COMMENTS ON APPELLANT'S STATEMENT

Planning Inspectorate Reference:	APP/T2350/W/23/3331604
LPA Application Reference:	3/2023/0221

Proposed field mounted 20kwp solar PV array (52 solar panels).

Lower Barn Farm, Whalley Road, Sabden BB7 9DT

PROPOSED SECTION AND PLAN

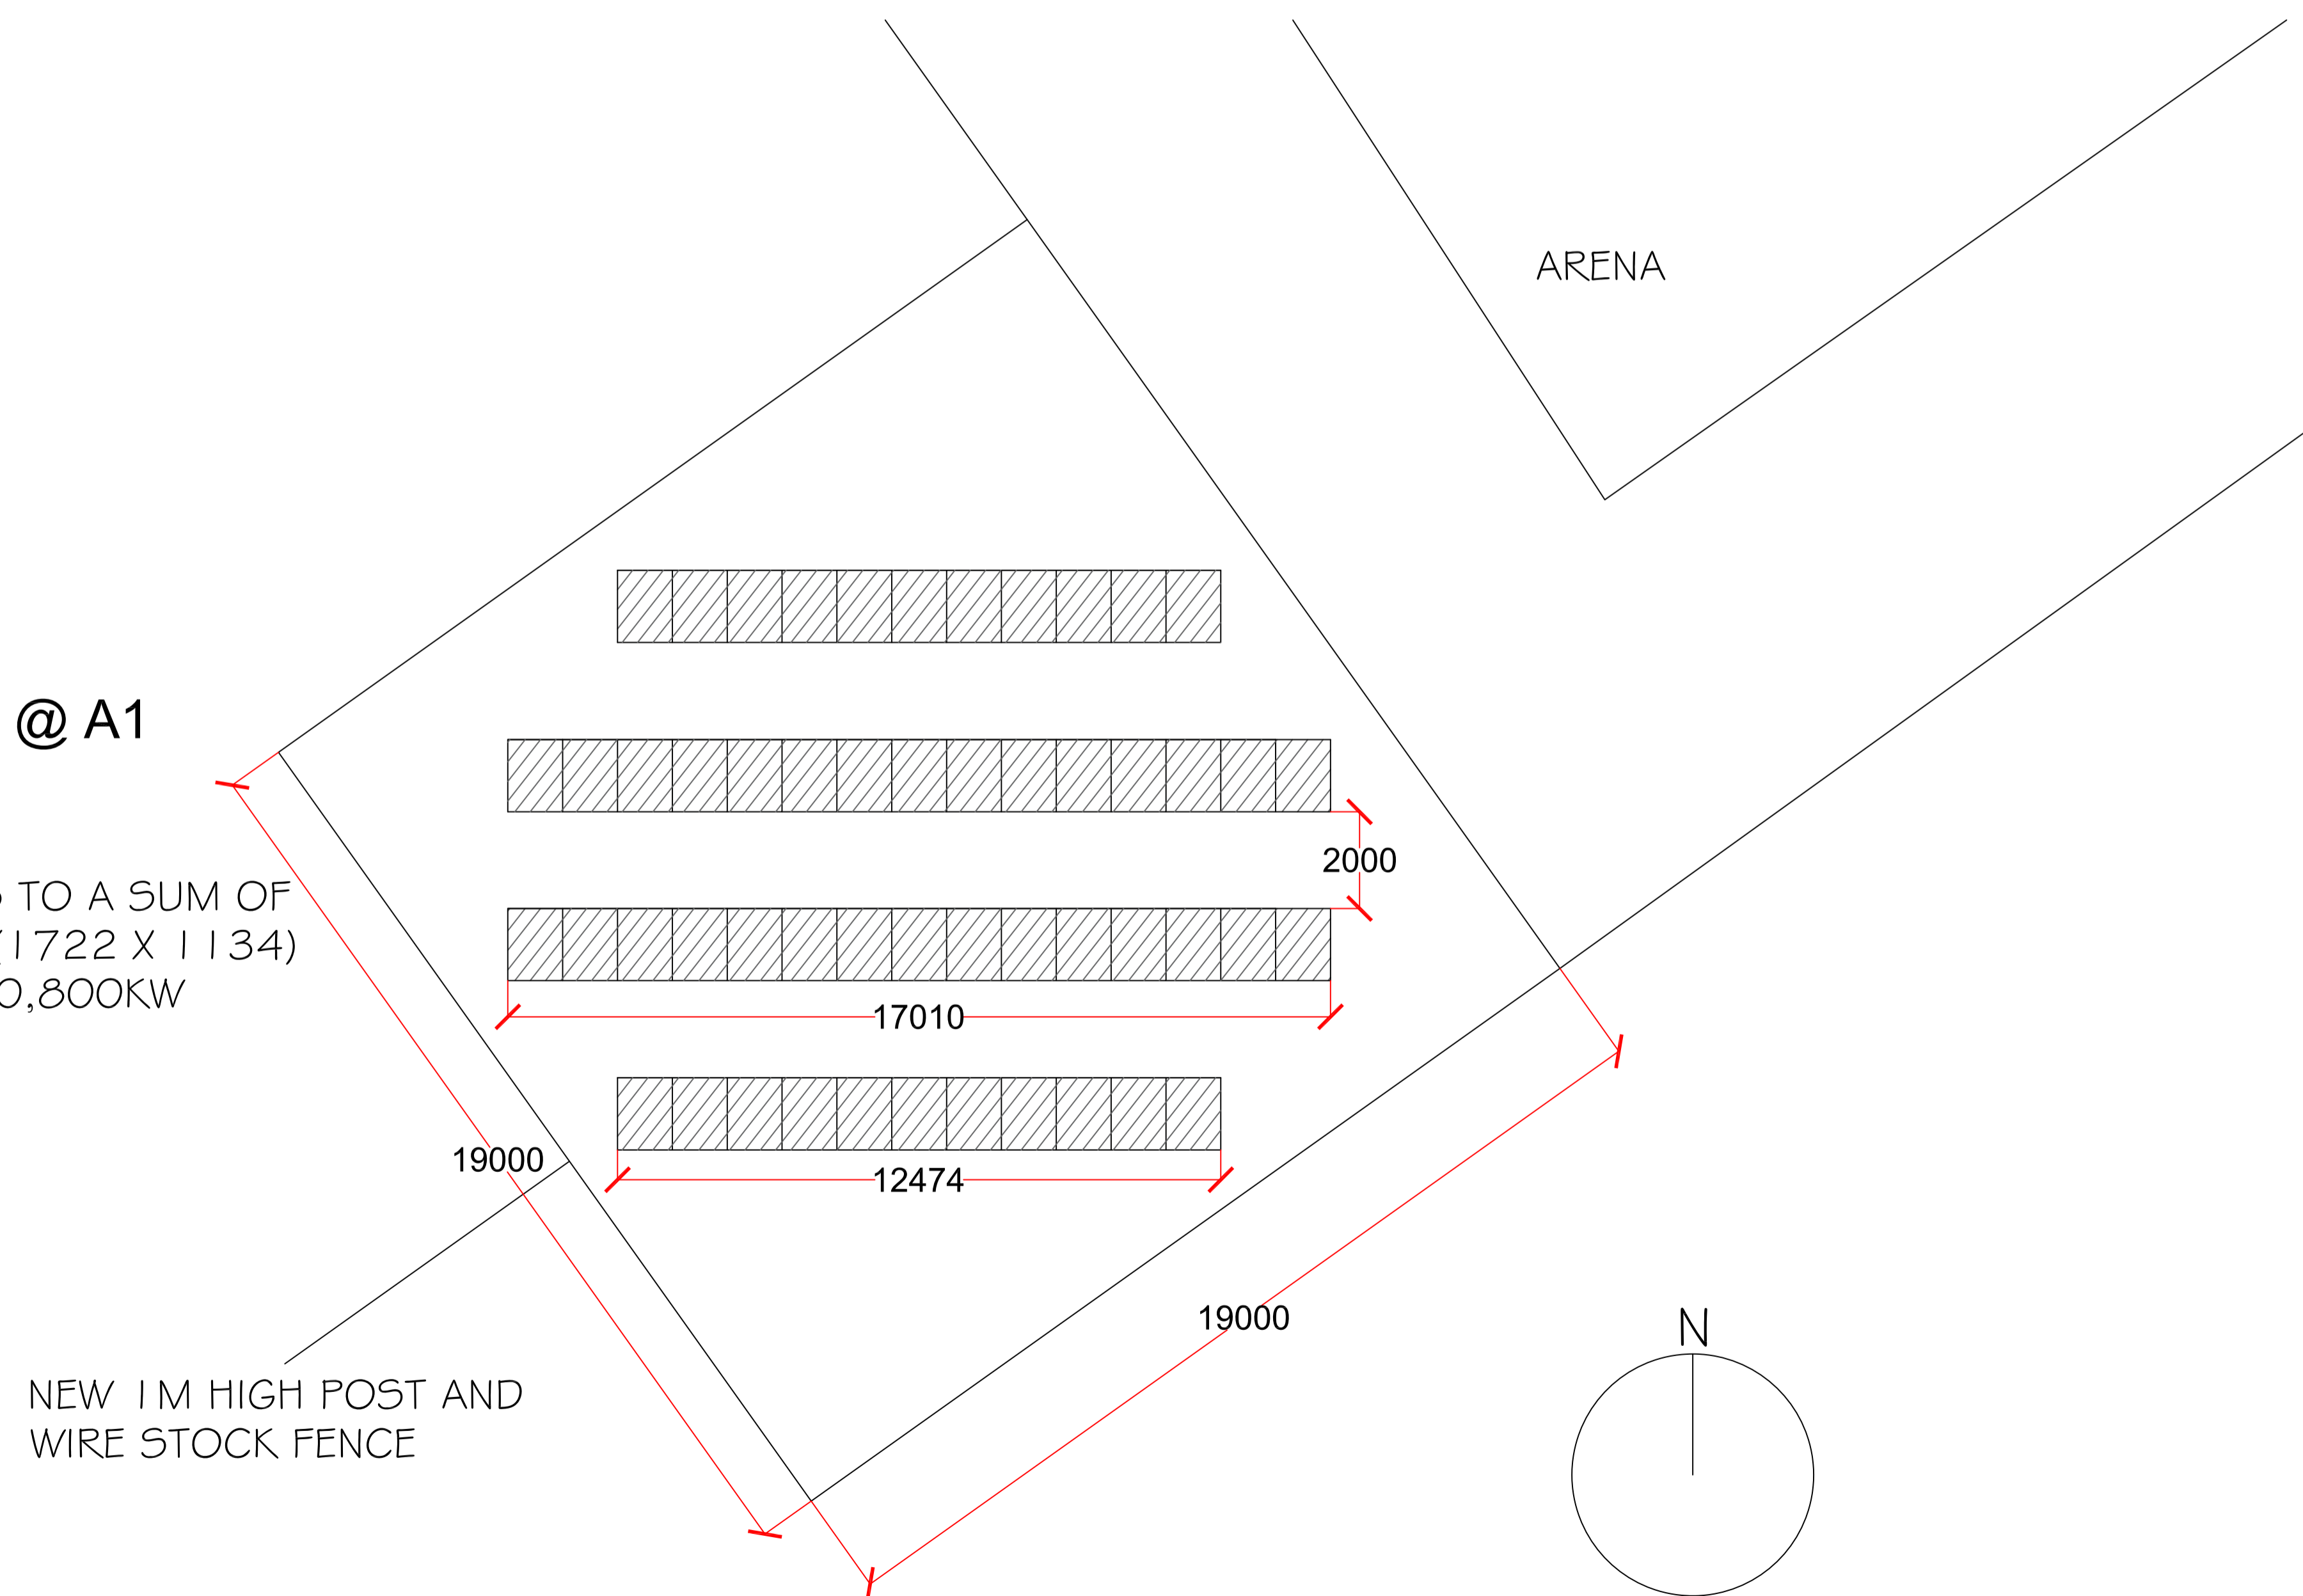
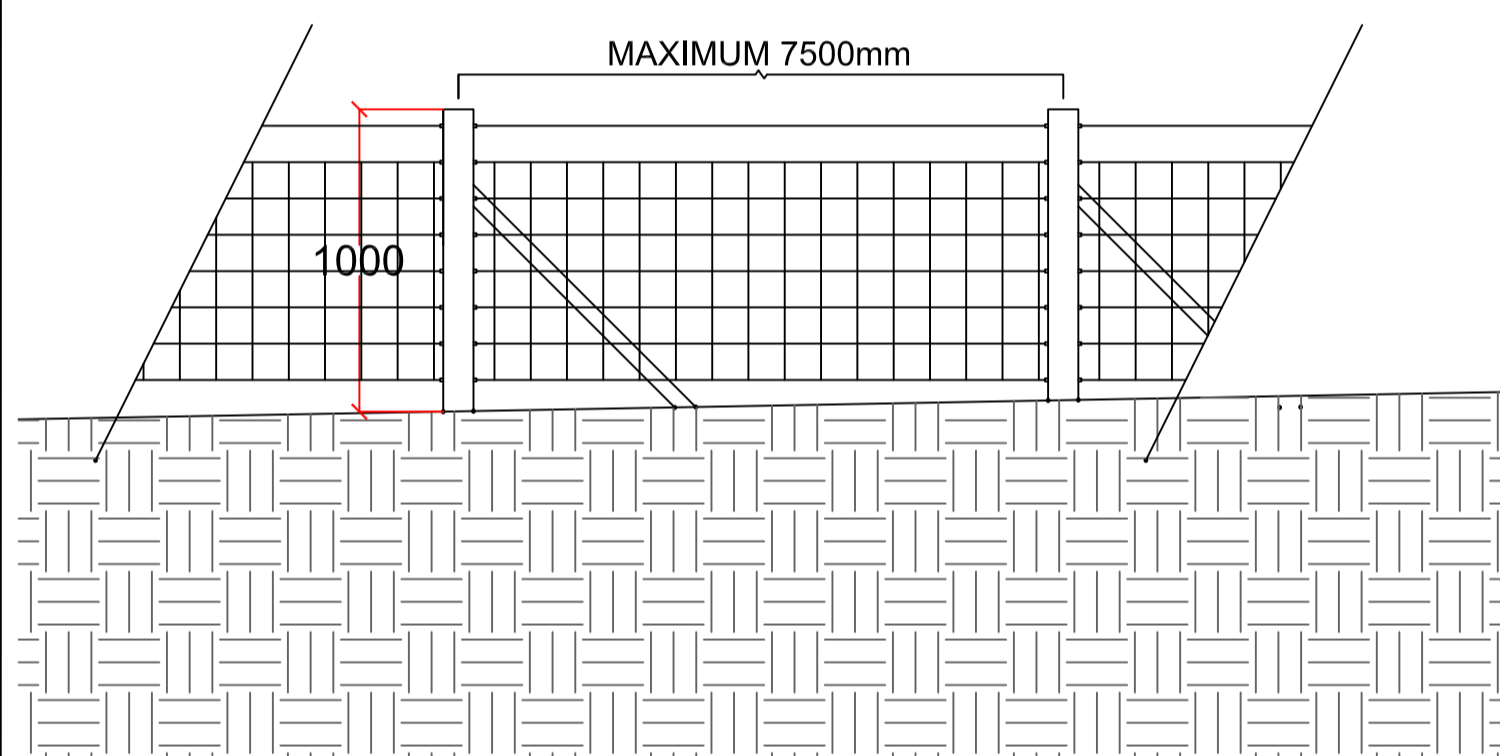
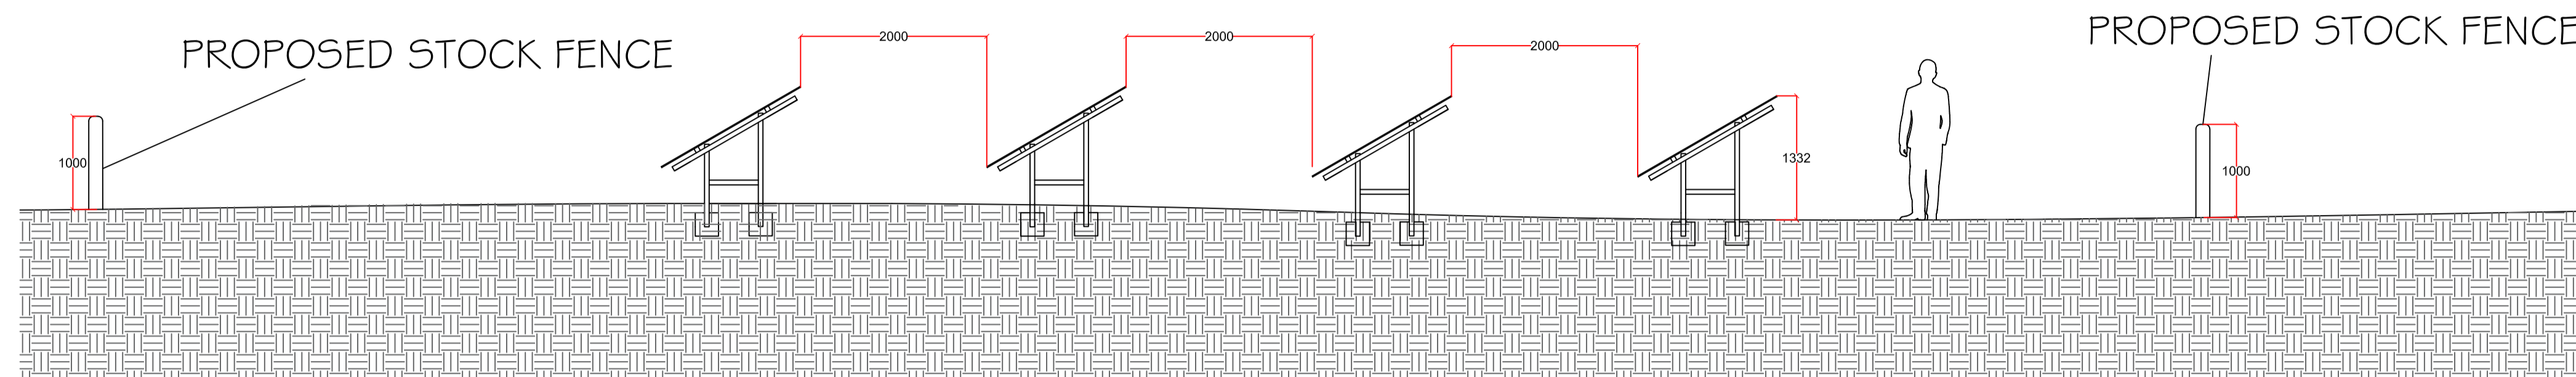
- 1.2 The proposed application as submitted made no reference to PROW 3-37-FP 113 (FP 113) both in the description or on the submitted site plan although footpaths 3-37-FP 96 and 3-37-FP 96 to the north are depicted. Following a site visit this was brought to the attention of the Appellant and a revised site plan was submitted which depicts 3-37-FP 113 but not in the correct position. The definitive map was checked and the location verified by LCC Highways prior to the decision being issued. The appellant was informed that the scheme was not acceptable on the basis of impact but choose to continue with the process in any event.

- 1.3 The Appellant's Statement of Case states that the panels are located in the least obtrusive position within the land. The panels are sited across FP 113 and therefore cannot be regarded as unobtrusive in that respect. Whilst the siting is adjacent to the Forest of Bowland National Landscape (NL) (previously known as AONB) it is still visible from, and clearly seen in context with the NL due to its relatively open nature and network of Prows in the area as well ad views from the public highway on Whalley Road.

- 1.4 The submitted photograph of the solar panels showing a double height had no weight in the determination of this application. The proposal was considered and refused on the basis of the submitted proposed section and plan PHA/823 500.

- 1.5 A copy of the definitive PRoW for footpath 113 has been provided by LCC Highways attached at Appendix 1. Thid clearly shows the footpath lines runs 14m from the existing boundary of the stables. As the solar panel siting would extend 19m from the same boundary clearly this would extend across the PRoW and require a formal diversion notice if found to be acceptable.

footpath 0337113 triggering a Diversion Order and therefore confirming the submitted plans are incorrect as indicated during the course of the application to the Agent. A decision was issued the same day as the comments received from LCC Footpaths as LCC Highways had already confirmed the definitive route of the footpath 117.

- 1.7 It is not clear why the appellant was aggrieved by the process as they were well aware of the presence of the PROWs in the area prior to submission and choose not to include the one affected by the proposal on the submitted site plan. The revised site plan shows footpath 113 but in a different location to that on the relevant GIS systems used by the LPA and LCC and therefore clarity was sought from the Agent and LCC Highways. This was confirmed in an email from the Agent on the 16th June prior to the decision being issued where it was stated that footpath 117 had not been shown as in his view it would not be affected. Upon receipt of confirmation from LCC Highways that the definitive route of footpath 117 would be adversely affected by the proposal the decision was issued.
